RE: ENGINEER'S CERTIFICATION FOR WEST LANG AVE - TRACT 1A (D-17/D3V)
RECEIVED NOVEMBER 7, 1995 FOR DRAINAGE REQUIREMENTS
ENGINEER'S STAMP DATED 11/6/95

This drainage report is prepared to present a master drainage plan for existing Tracts 1A-1, Journal Center Business Park. This tract of land is proposed for subdivision into several new tracts, Tracts 1A-2, 1A-3, 1A-4 and 1A-5. Additionally, and simultaneously, a new public road right-of-way called Lang Avenue is to be created.

LANG AVENUE

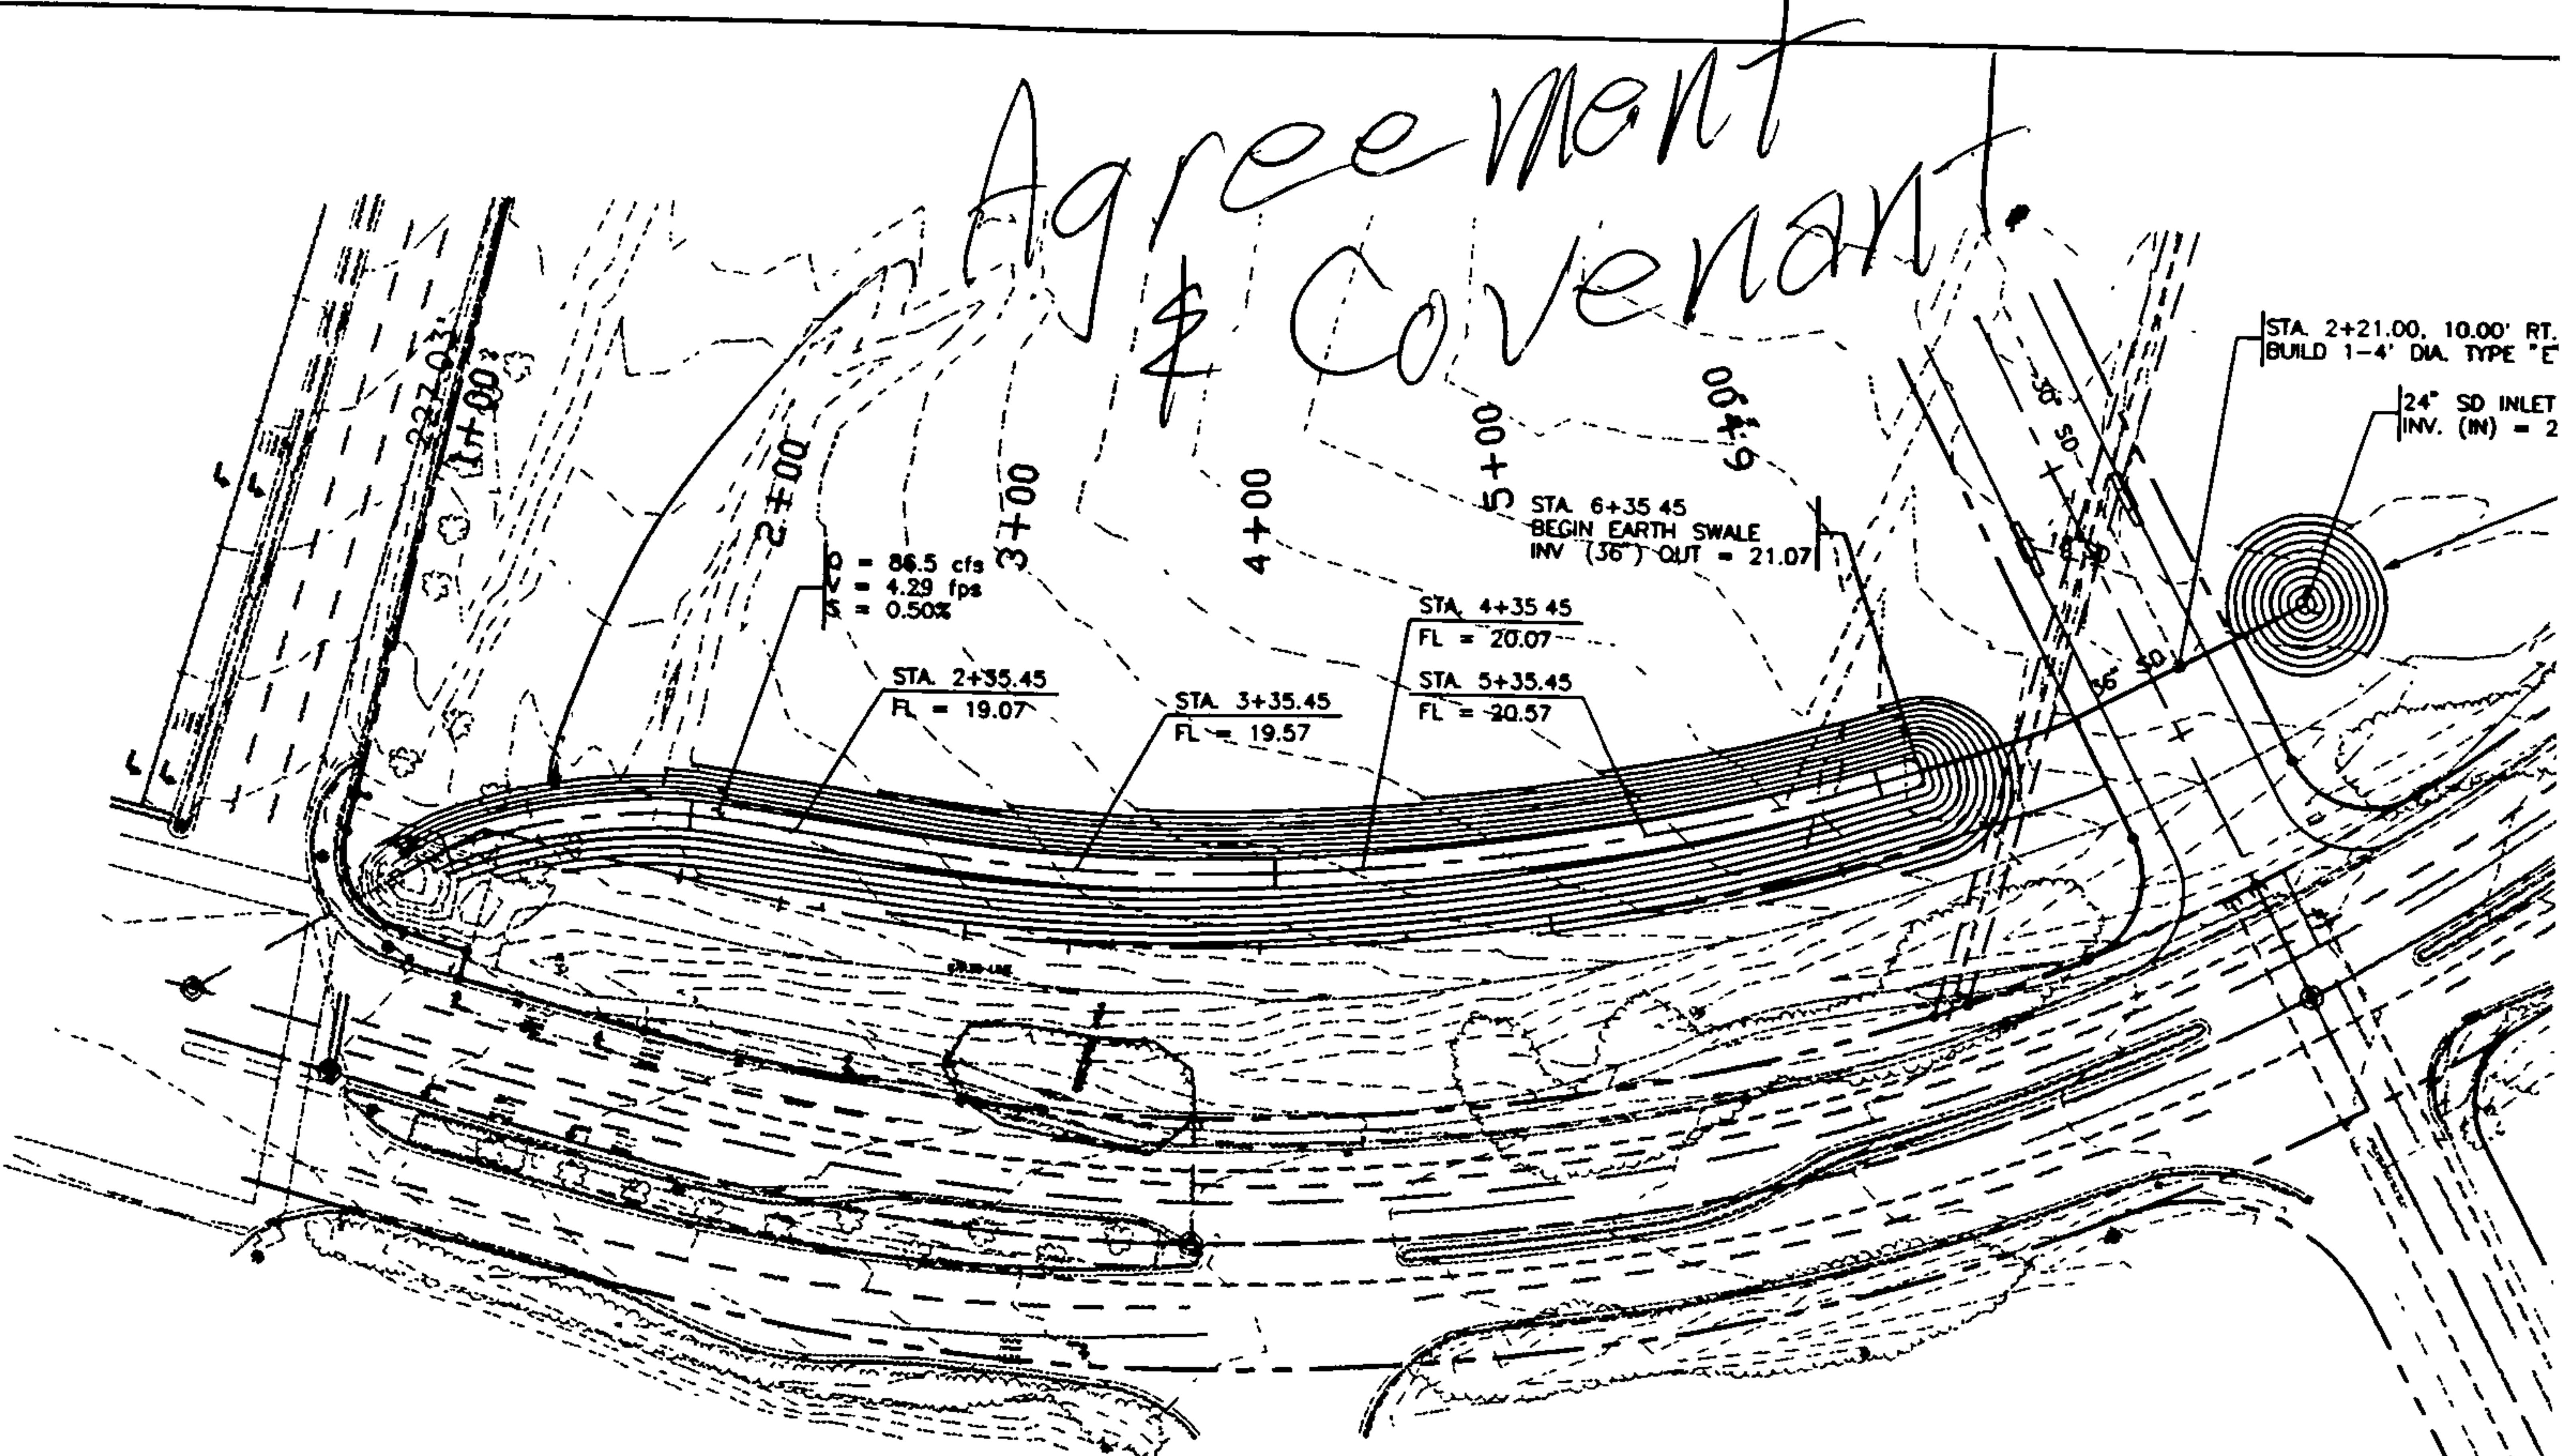
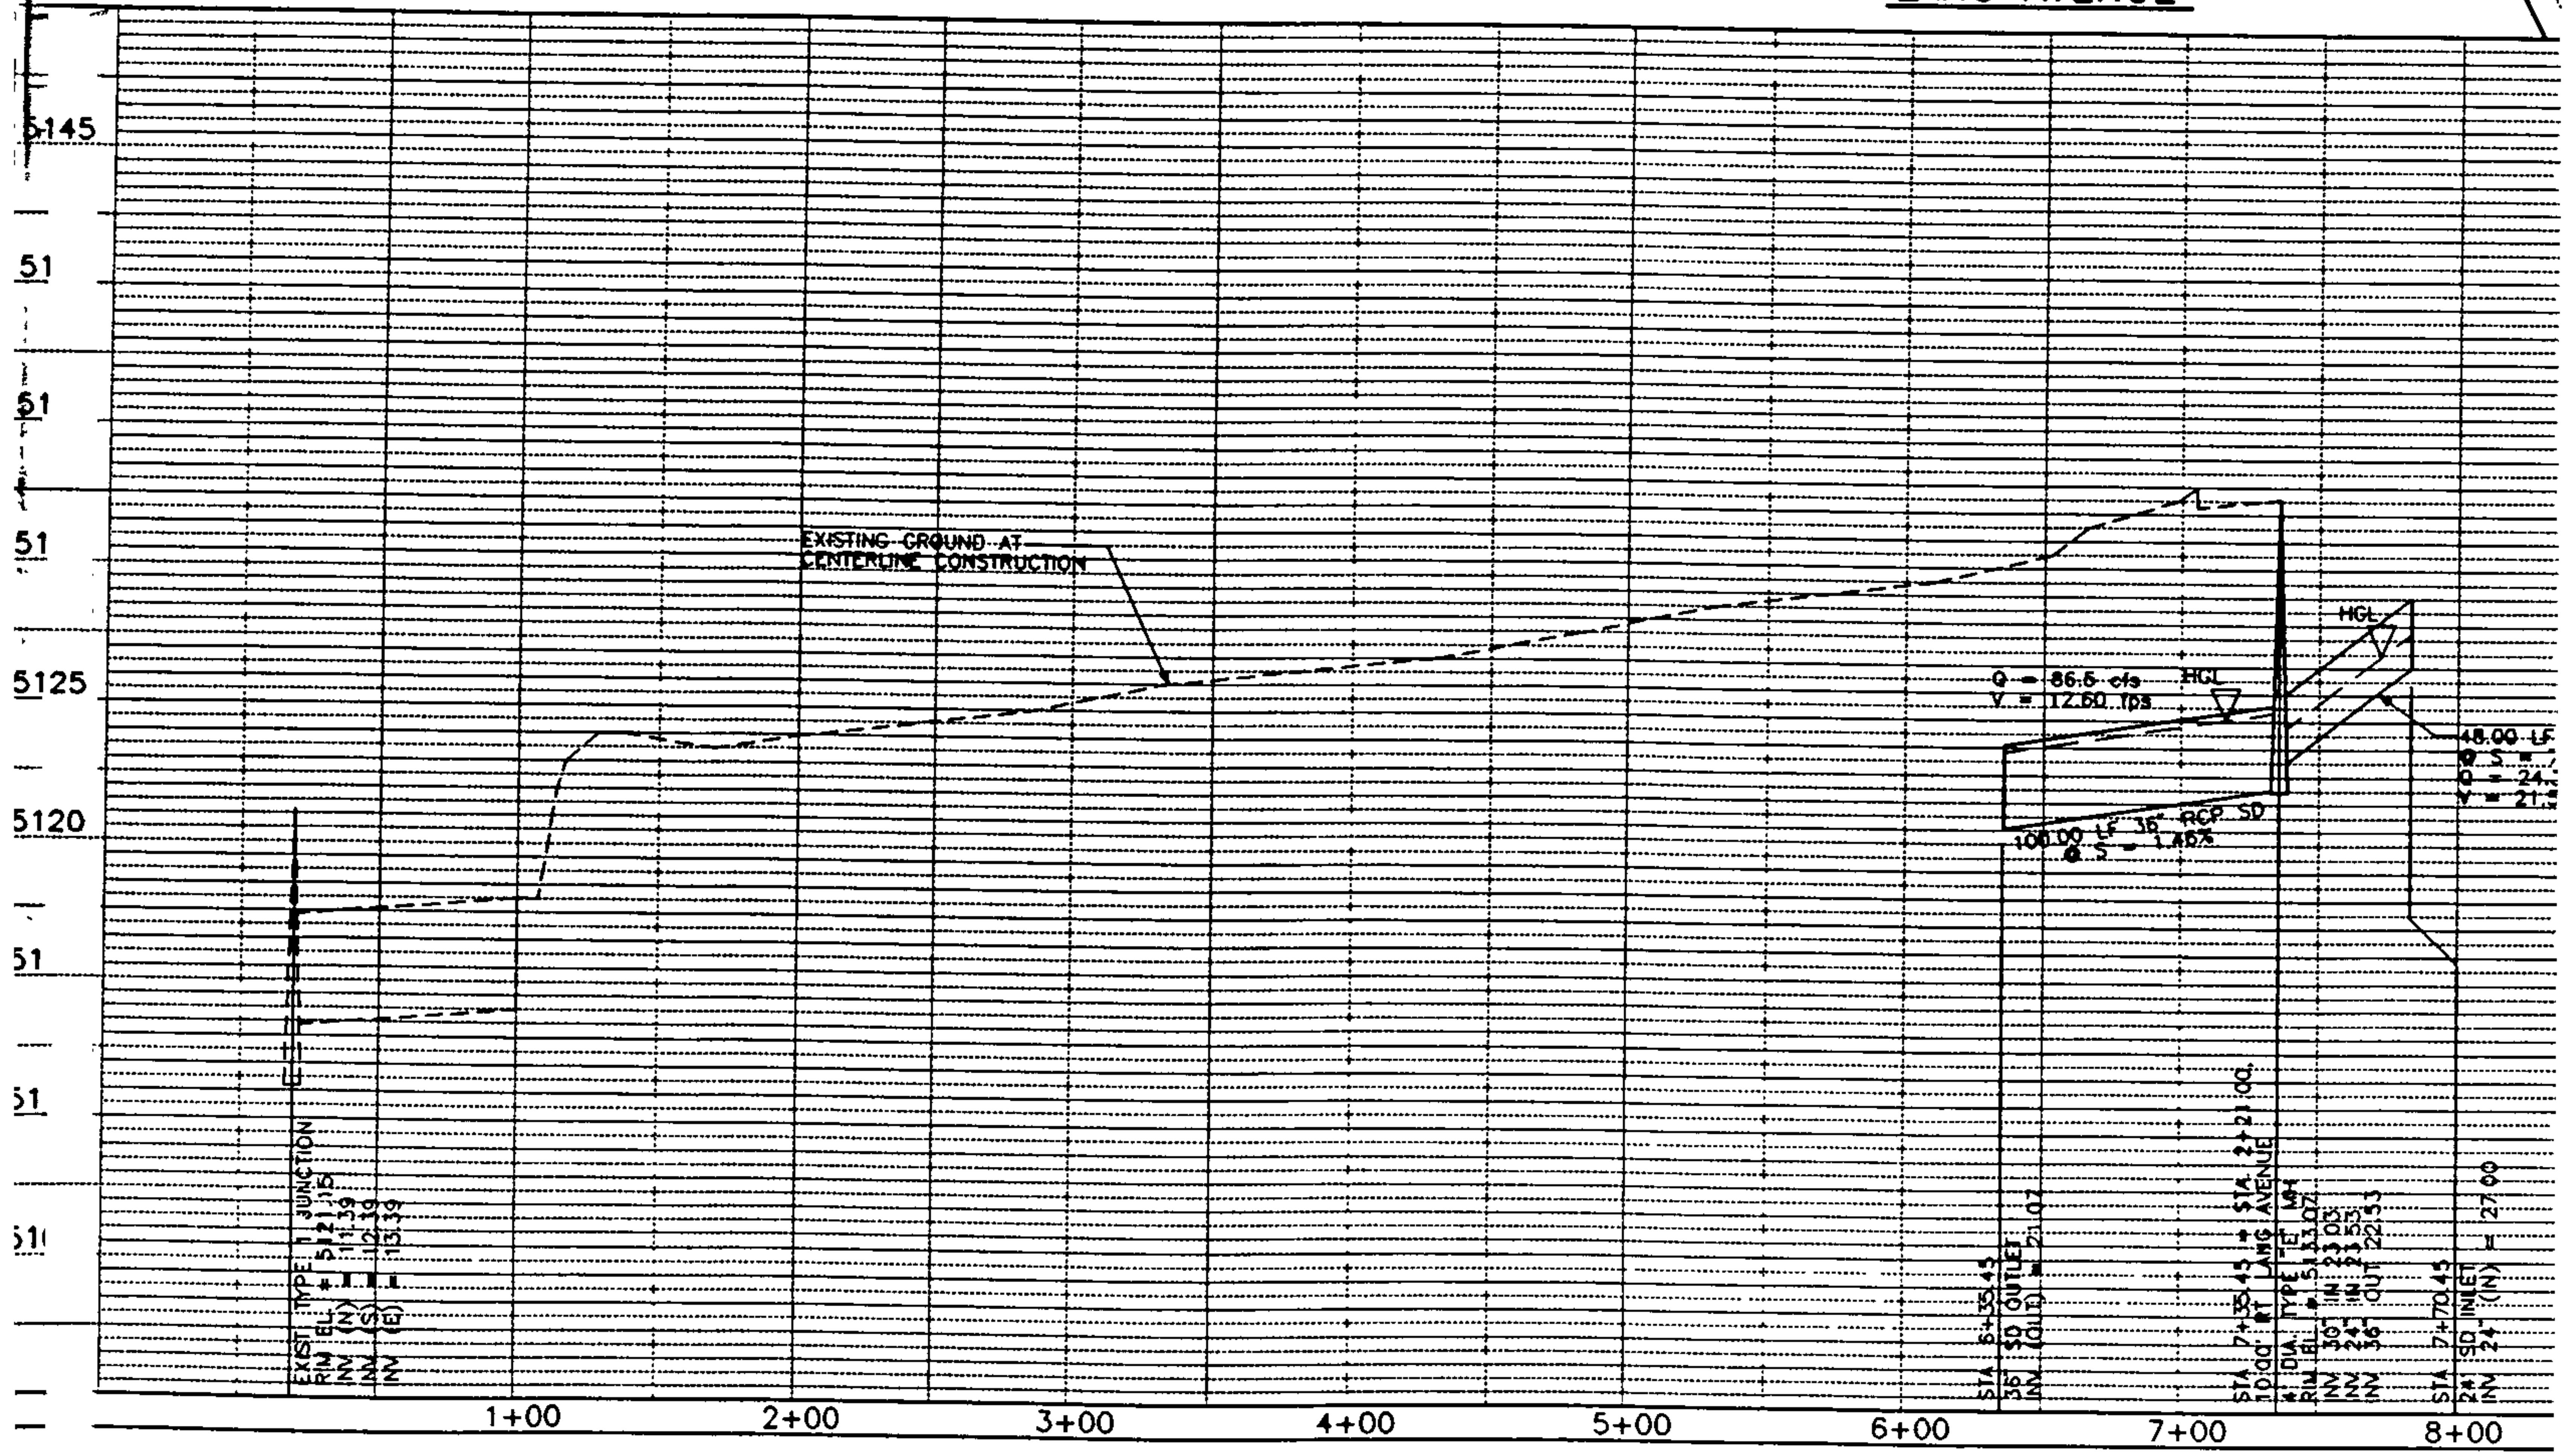
How does Tract 1A-4 drain to Lang?
